Sea Link

Document 9.65: Draft Statement of Common Ground Between National Grid Electricity Transmission and the National Trust.

Planning Inspectorate Reference: EN020026

Version: **AB**

PLAN VIEW

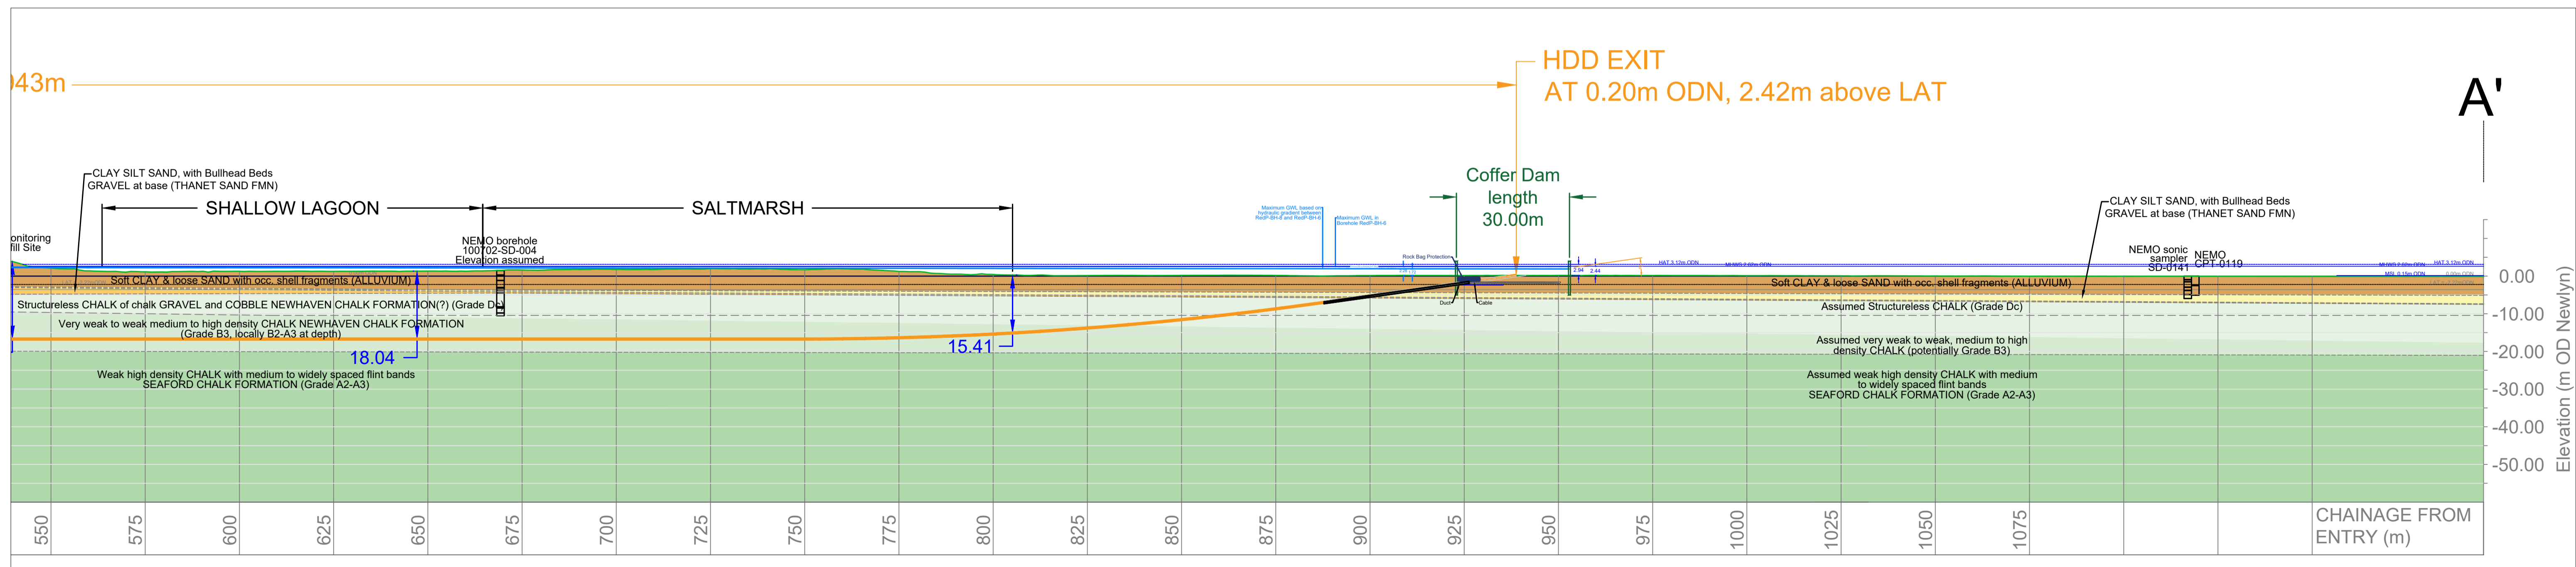
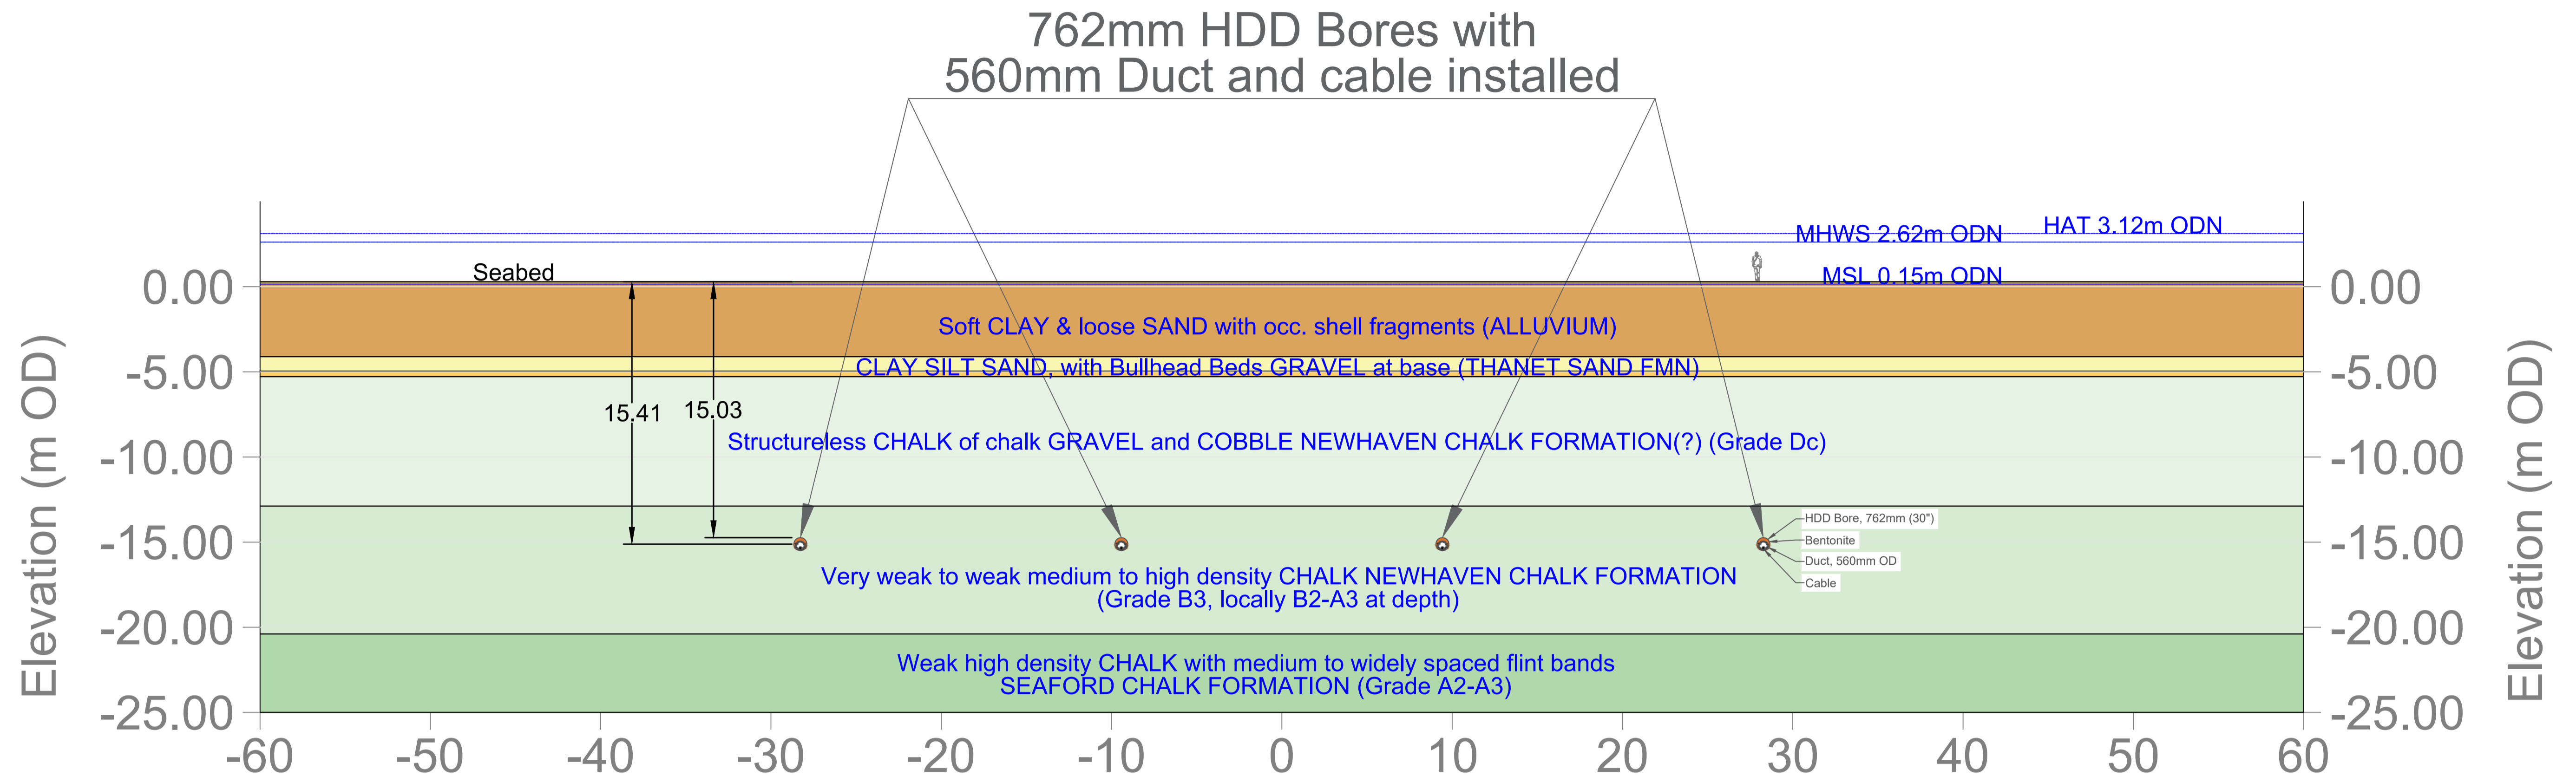
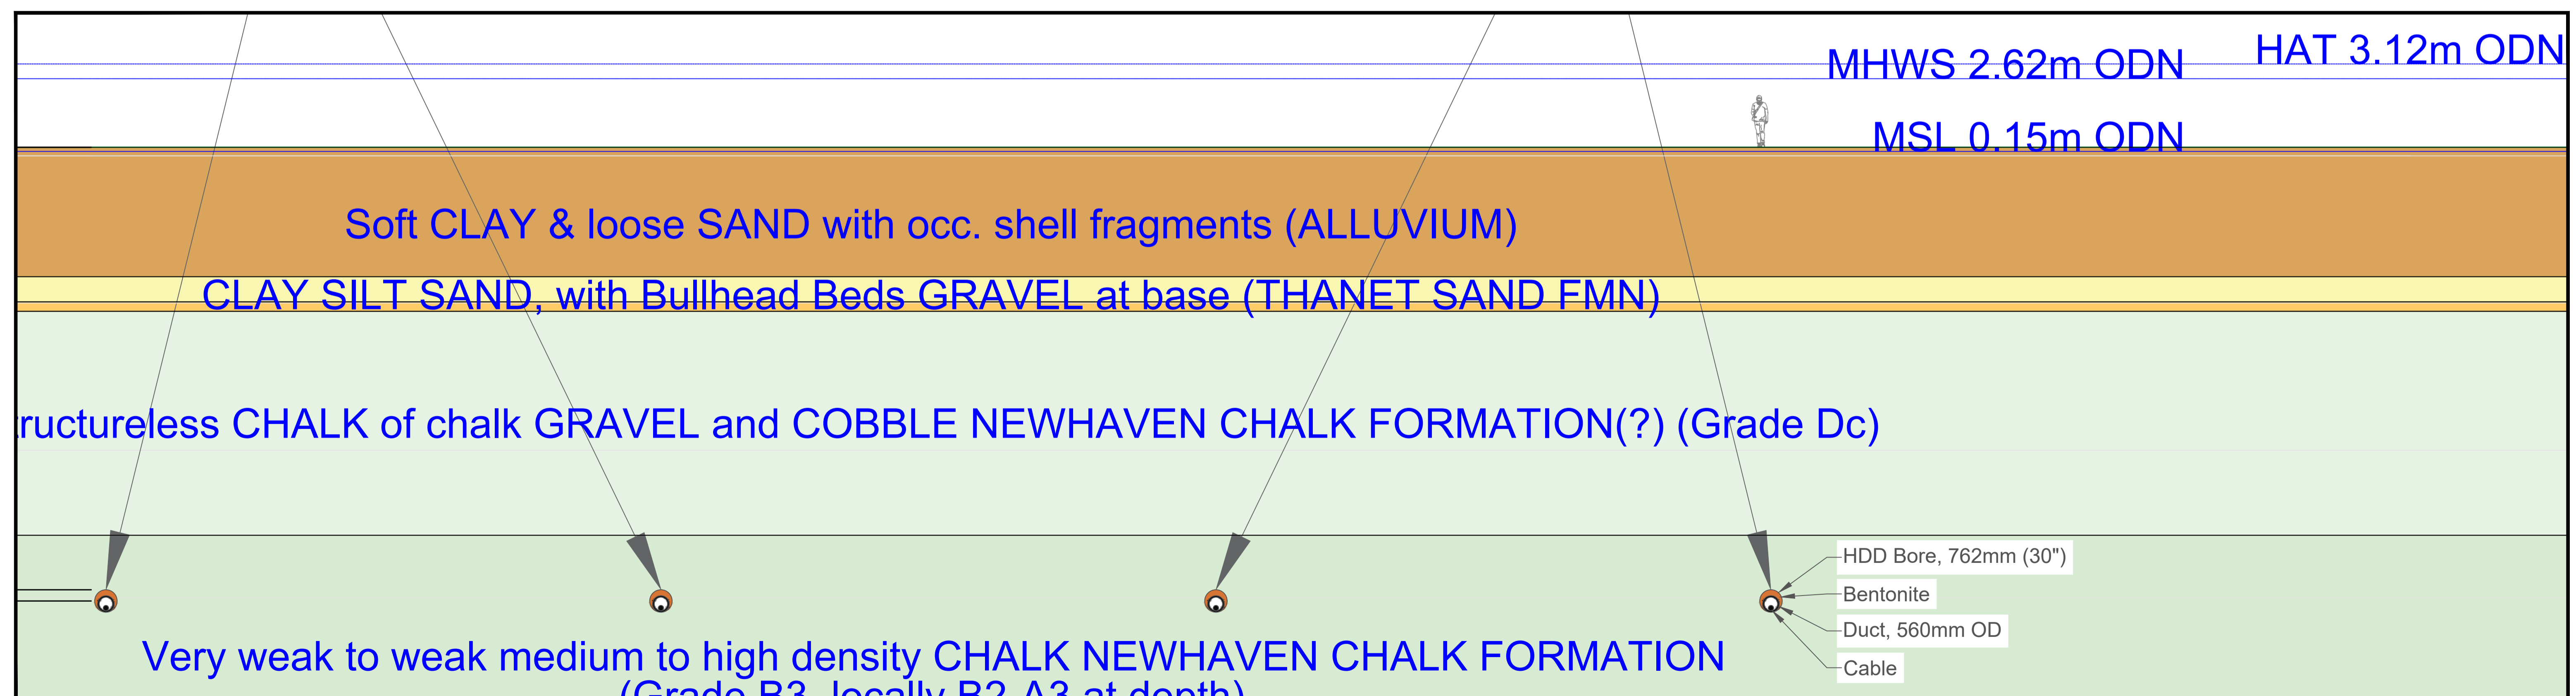
Ref	Relevant Application Documents	Description of Matter	Consultee's Current Position	The Applicant Current Position	Status
Chapter 2		Horizontal Direct Drilling (HDD) Impacts on Ecological designations on National Trust Land	<p>The National Trust does not object to the principle of the proposed offshore high voltage direct current link between Suffolk and Kent with onshore converter stations and connections back to the national electricity transmission system.</p> <p>We would support the developer's use of Horizontal Directional Drilling (HDD) construction methods at Pegwell Bay and would expect to see a firm commitment to undertake this form of engineering if this proves to be less detrimental than other alternatives. The entry point for the HDD is 470m west of the SAC/SPA/SSSI and Trust land. It is proposed to drill at 15-18m depth under the saltmarsh, and the exit point will be to the east of the saltmarsh in intertidal mudflat (Figure 6.4.4.2.4 Habitats present at, and location of, trenchless solution entry/exit points). However, the method statements do not rule out the need for trench installation if HDD proves to be difficult/impossible to use. If trenchless techniques are used, the Trust would have concerns due to the potential of the cumulative impacts on the Nature Reserve arising due to the possibility of the proliferation of cables installed previously for the Nemo link. Consequently, the Trust would want assurances that there will be nothing above ground on our land.</p> <p><u>The Trust welcomes the Applicant's confirmation. The Trust seeks in addition that the Applicant completes an HDD Management Plan after first consulting with the Trust and other relevant stakeholders.</u></p>	<p>The current draft DCO prohibits cable installation in Pegwell Bay using techniques that are not trenchless- <a href="#">to cross the sensitive saltmarsh</a>. If other than a trenchless technique were proposed at this location, any proposals for alternative methods would require a formal amendment to the DCO and would need to be supported by an additional environmental assessment.</p> <p>However, as outlined in <b>Application Document 7.3 Design Development Report – Appendix A Landfall HDD Feasibility Technical Note [APP-321]</b>, ground investigations have confirmed suitable drilling conditions for HDD. The report states that initial hydrofracture modelling, using ground strength parameters from the ground investigations, shows a 2.8 factor of safety against frac out. This means that the drilling fluid pressure would need to be 2.8 times the pressure required to drill through the formation, to cause a surface frac out in the SSSI. Therefore, there is a very low risk of frac out.</p> <p><u>The Applicant can confirm that the HDD contractor will produce a detailed, drilling fluid management plan to be approved by the MMO in consultation with relevant stakeholders including Natural England, that includes drilling fluid breakout mitigation measures, where HDD is proposed. This is currently secured within the Deemed Marine Licence through <b>Application Document 9.92 (A) Outline Cable Specification and Installation Plan [REP4-090]</b> submitted at Deadline 4, <b>Application Document 7.5.2 (B) Outline Offshore Construction Environmental Management Plan [REP4-223]</b>, and also within <b>Application Document 9.84 (B) Register of Environmental Actions and Commitments [REP4-234]</b> under <b>B59</b>.</u></p> <p><u>In addition to the above, a HDD Landfall Method Statement will be developed following detailed design which is currently secured within the Deemed Marine Licence through <b>Application Document 7.5.2 (A) Outline Offshore Construction Environmental Management Plan [APP-339]</b>. The National Trust will be consulted on this document.</u></p> <p><u>A list of relevant securing mechanisms for the Proposed Project is provided in Appendix A. In addition to this, a cross sectional image</u></p>	Under discussion

Construction methods and mitigation		<p>Given the potential impact this proposal could have on the significant nature designations at Pegwell Bay, the National Trust request more in-depth details on the construction and design methods than would usually be available during the Development Consent Order (DCO) process, so that we can be reassured that the works proposed will provide the highest level of mitigation possible.</p> <p>The National Trust would encourage the developer to consider additional mitigation in the form of funding to support the ongoing management and future conservation of important coastal and marine species and habitats in the Pegwell Bay and Sandwich Bay SAC area and would welcome further discussion on this topic during the DCO process with the National Trust as landowner, the Kent Wildlife Trust as site manager and other key stakeholders.</p> <p><a href="#">The Trust considers there remains significant areas of uncertainty around the details of construction and potential ecological impacts. The includes, but is not limited to the impact of x4 ducts running through the SSSI intertidal habitat (requiring a 80m and not 30m wide easement) which the applicant has recently advised the Trust within the last week.</a></p> <p><a href="#">It is not clear to the Trust how the applicant has applied the mitigation hierarchy in relation to impacts on the Sandwich Bay to Hacklinge Marshes SSSI.</a></p> <p><a href="#">The location of the exit points are not clear. It would be clear if these are shown on a location plan with the pits dimensionally referenced (horizontally and vertically) to the MHWS and MLWS. Its also not clear if the exit pits will comprise a permanent buried construction of if they are simply locations within the cofferdams at the</a></p>	<p>Further project description information in regard to Pegwell Bay <a href="#">construction activities</a> is available in <b>Application Document 9.13 (C) Pegwell Bay Construction Method Technical Note, submitted at Deadline 1. [REP4-229]</b></p> <p>As presented in <b>Application Document 6.2.4.1 (BE) Part 4 Marine Chapter 1 Physical Environment [AS113/AS114REP4-027]</b>, at Pegwell Bay, the magnitude of the impact on nearshore physical processes morphology due to the excavation of the HDD pits and wider cable installation is small as works will be temporary, relatively localised and any changes to the in the intertidal zone seafloor morphology will naturally recover via sediment transport processes driven by wave and current action in shallow waters.</p> <p>There will, therefore, be no significant effects to intertidal or shallow subtidal ecology <a href="#">or morphology</a>. As no significant effects are concluded, no further additional mitigation than currently outlined in <b>APP-342 Document 7.5.3.2 (B) CEMP Appendix B Register of Environmental Actions and Commitments (REAC) [CR1-043]</b> is proposed.</p> <p><a href="#">-A meeting was held on MS Teams between National Grid and the National Trust to discuss Application Document 9.13 (C) Pegwell Bay Construction Method Technical Note [REP4-229] on 11/02/2026.</a></p> <p><a href="#">The Applicant has provided a more detailed image of the intertidal exit pits including MHWS and MLWS in Appendix B. Additionally, a vertical cross section of the HDD profile at Pegwell Bay is also included within Appendix B.</a></p> <p><a href="#">The exit pits during HDD construction are temporary excavations within the planned cofferdams to finalise the below ground</a></p>	Under discussion
